<b>Company Name:</b>	Department of Planning, Industry and Environment
<b>Attn:</b>	Lucinda Craig / Lara Fusco
<b>Date:</b>	8 December 2021
<b>Re:</b>	Request for additional information
<b>Project Name:</b>	Ivanhoe Stage 1 SSD DA - MOD 3

drawing title:
**ADDITIONAL TREES
TO BE REMOVED**

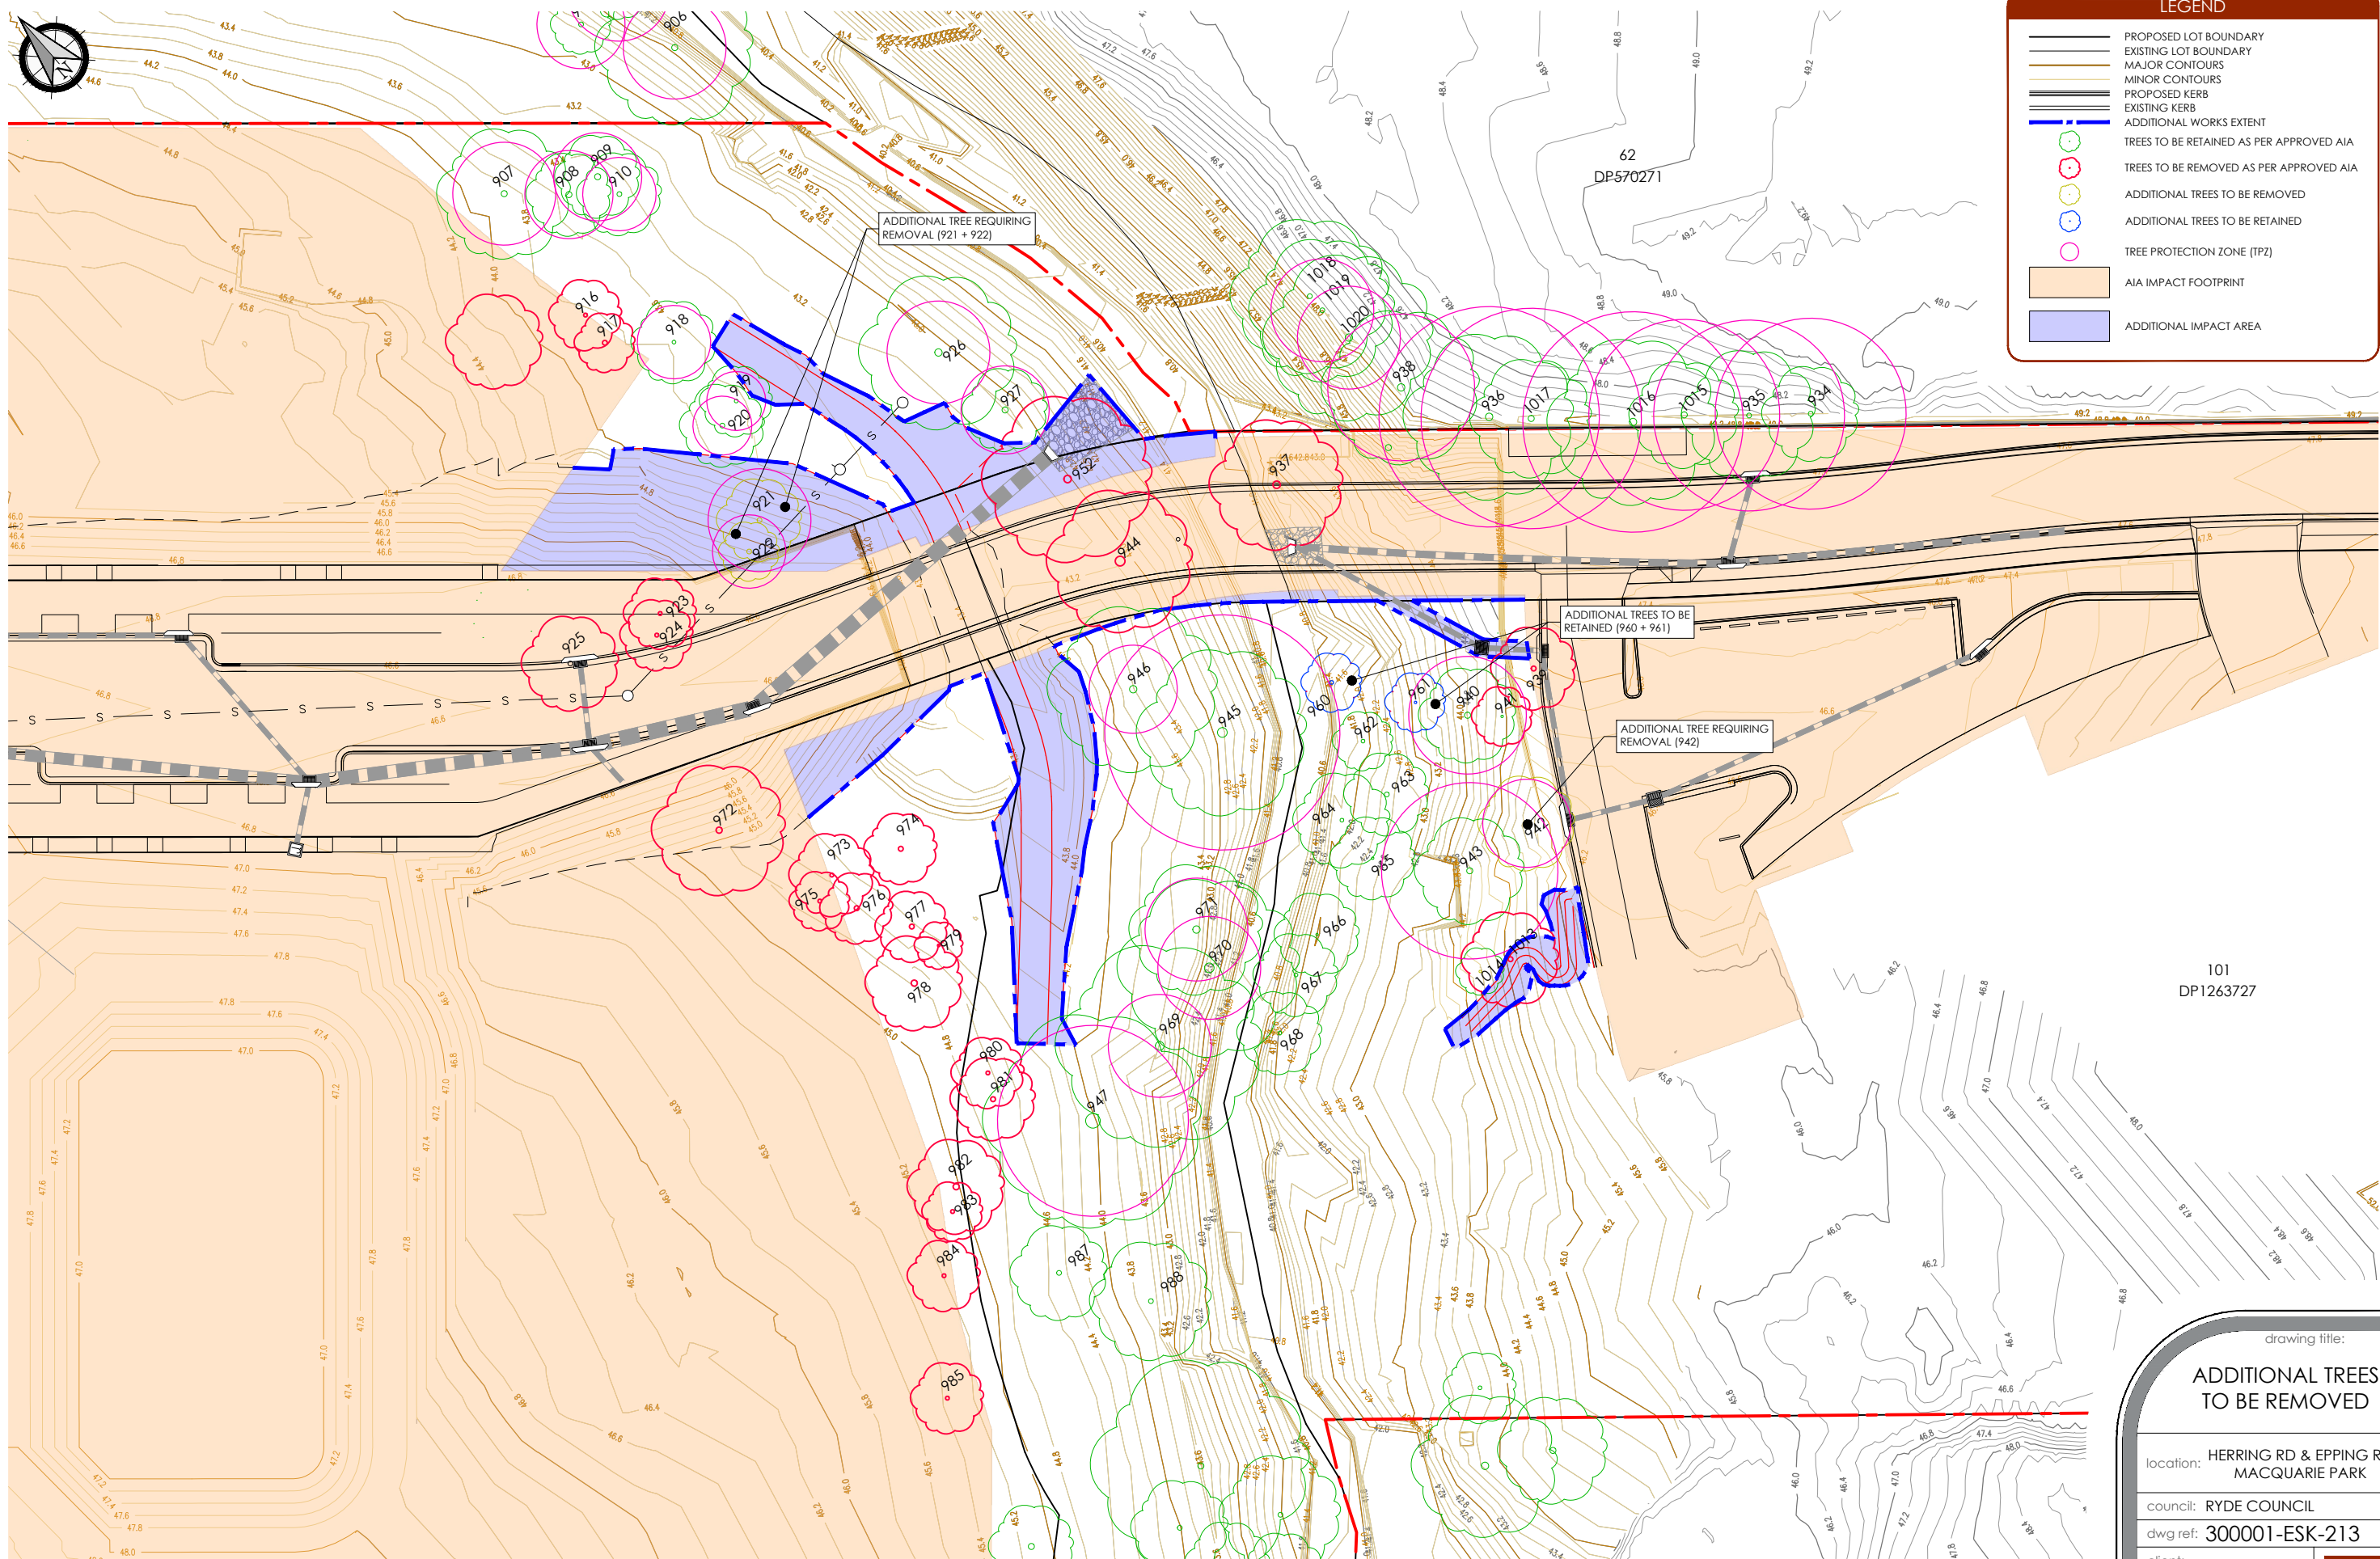
- As detailed in the Modification Application, while ever effort has been made to retain and protect trees “where design allows”, compliance with Condition B103 of the Stage 1 consent that requires widening the bridge connection through the site, will unavoidably impact Trees 921 and 922 and as such these trees are required to be removed. This is likewise the case for Tree 942 that is unavoidably impacted by the stormwater network.

- The angophora trees (Trees 921 and 922) were considered to have high retention value under the original Arboricultural Impact Assessment. Section 2.2 of that assessment confirms the relevant considerations for the different classification categories. These categories detail the order of priority trees for retention to removal where design allows. As detailed, compliance with Conditions B103 of the consent requires that the bridge be widened post-approval which has unavoidably impacted these trees. Compliance with Condition B103 has meant that these angophora trees cannot be retained.

- The specific details for the two trees to be retained on the site has been provided in the appended letter from EcoLogical (see Table 2 of the letter dated 1 December 2021) including the species, height, and diameter of these trees. The trees to be retained are mature Casurina Cunninghamiana trees, commonly known as ‘River Oak’, which is a native species endemic besides creeks and rivers.
